From: Brian Wilson [brian@whag84.fsnet.co.uk]
Sent: 16 April 2015 14:59
To: billgreensmith@msn.com
Cc: Mark Peacock
Subject: Planning Application No. S6/2015/0524/FP

re: Planning Applications Received by Welwyn Hatfield Council

Application No.	Description and Location	Applicant/Agent
S6/2015/0524/FP	Erection of dwelling house following the demolition of redundant structure. Woodfield Woodfield Land Hatfield AL9 6JJ	Mr B Greensmith BGA 29 Limes Avenue London N12 8QN

Drawing Title
EXTERNAL WORKS

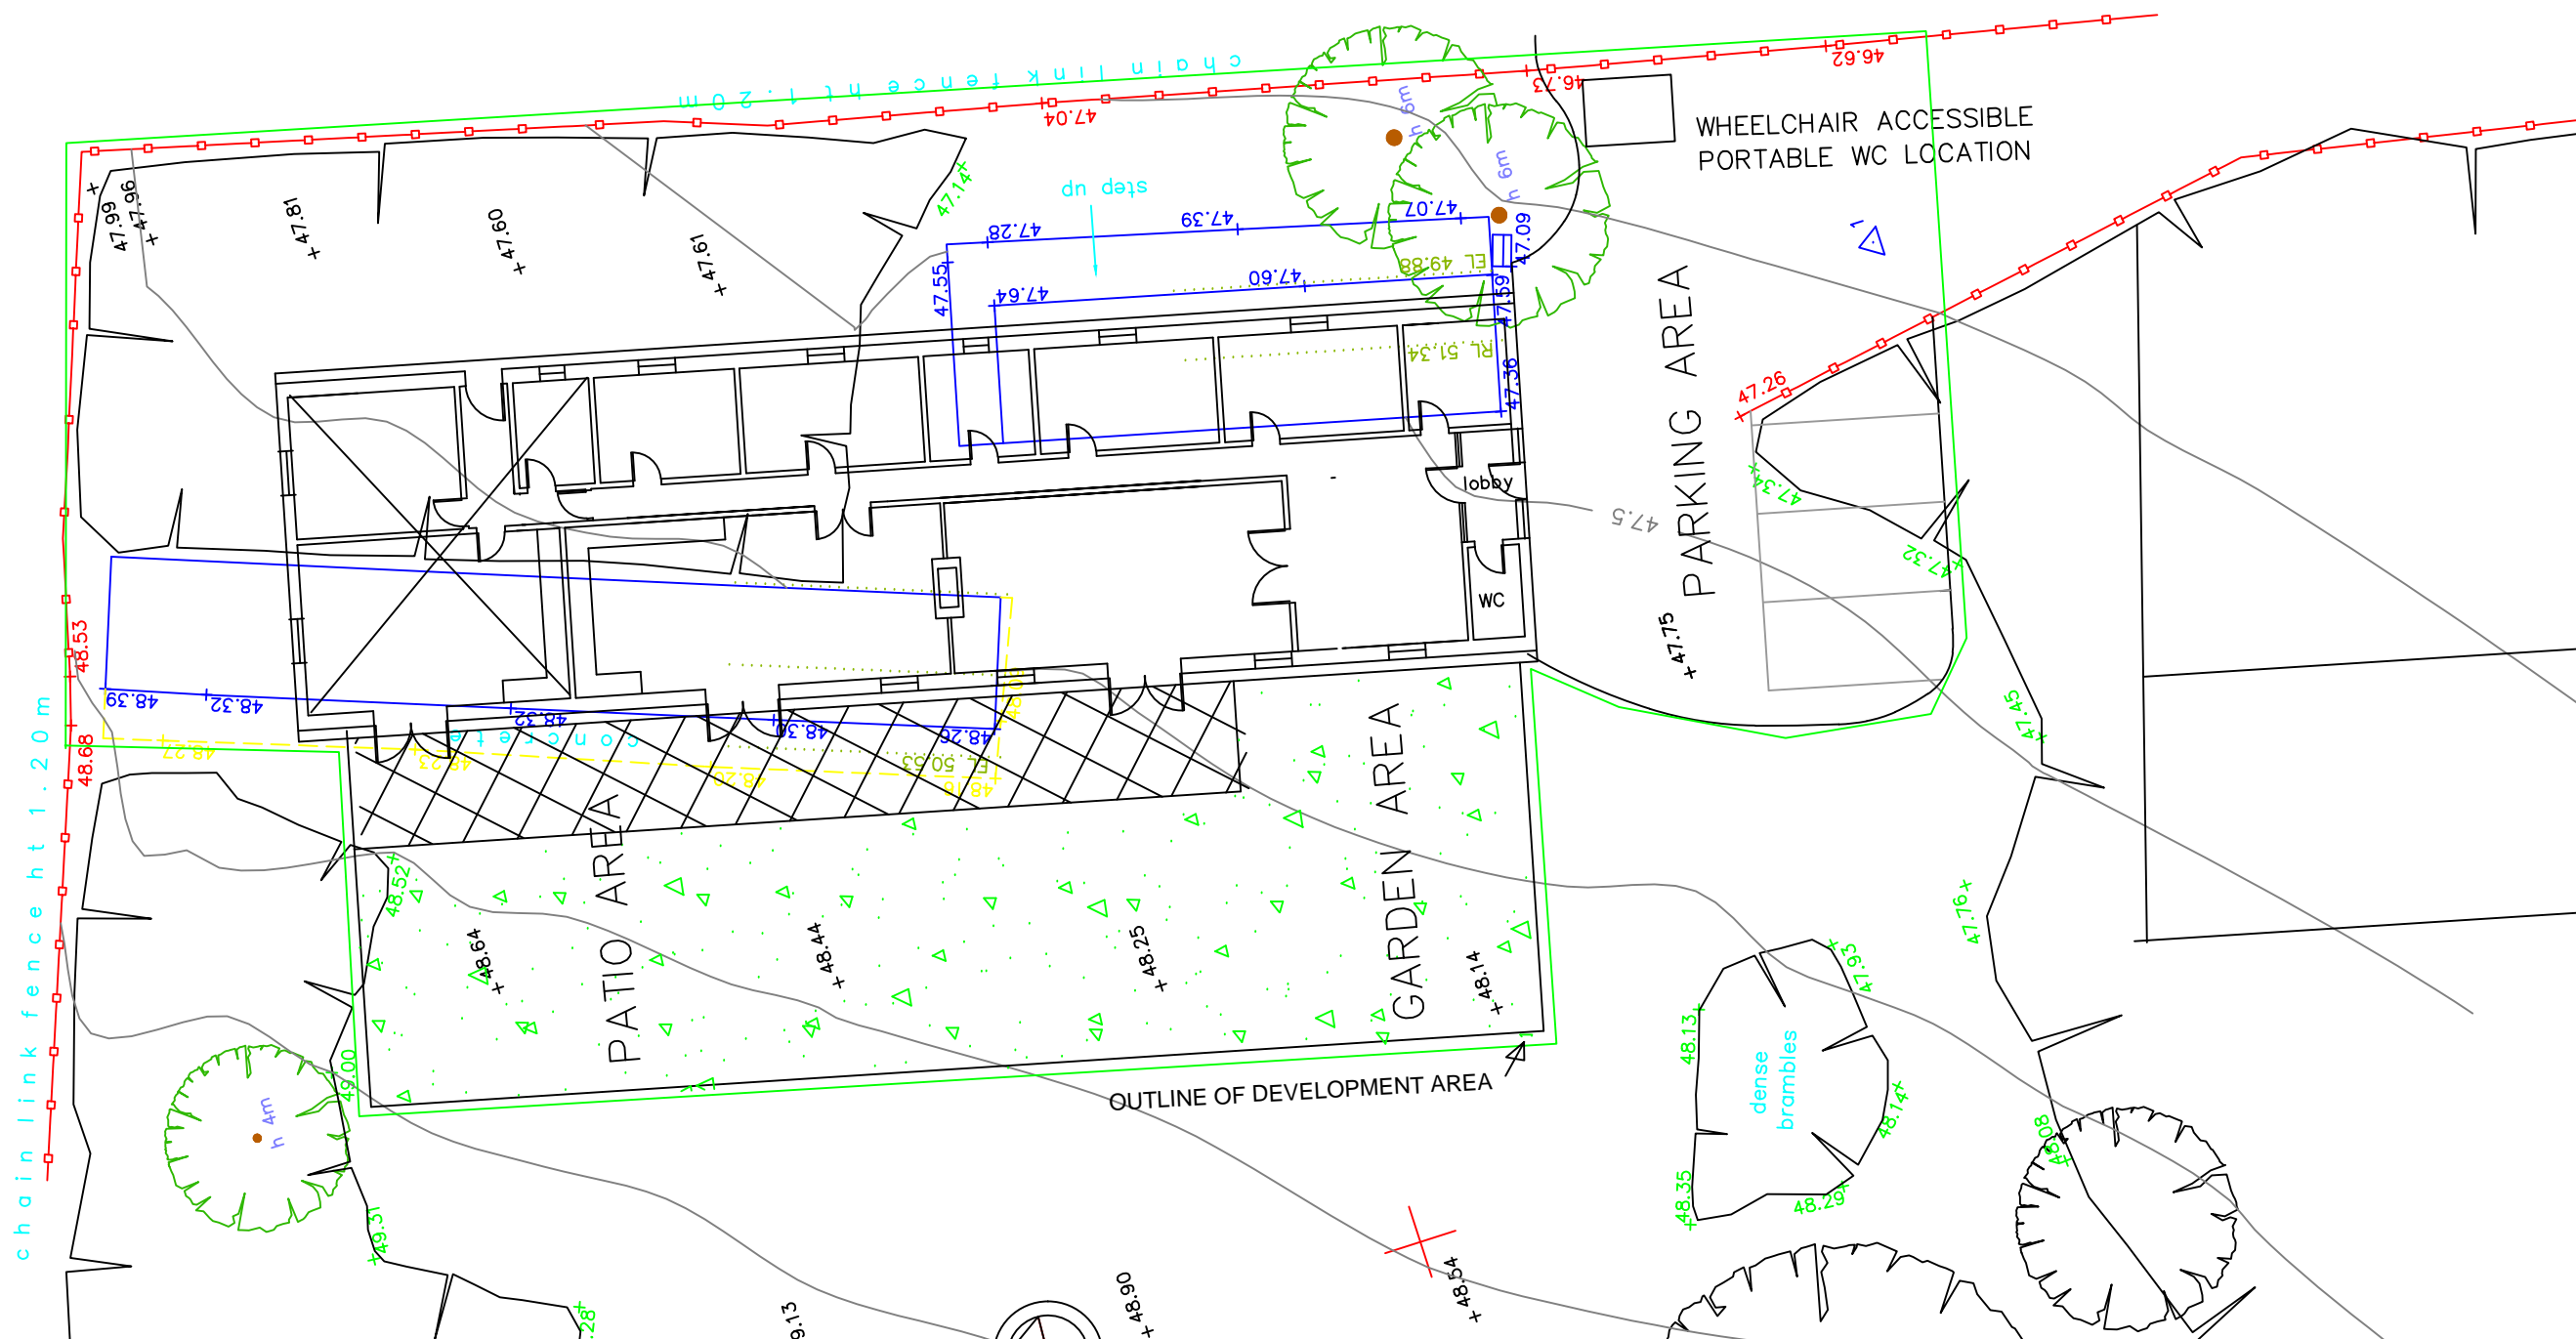
Finally, we are exceedingly interested in your comments about community involvement. Obviously, if members of the general public are to be given access to the proposed site there needs to be appropriate facilities onsite for them. Have you considered this aspect and, if so, what are your proposals?
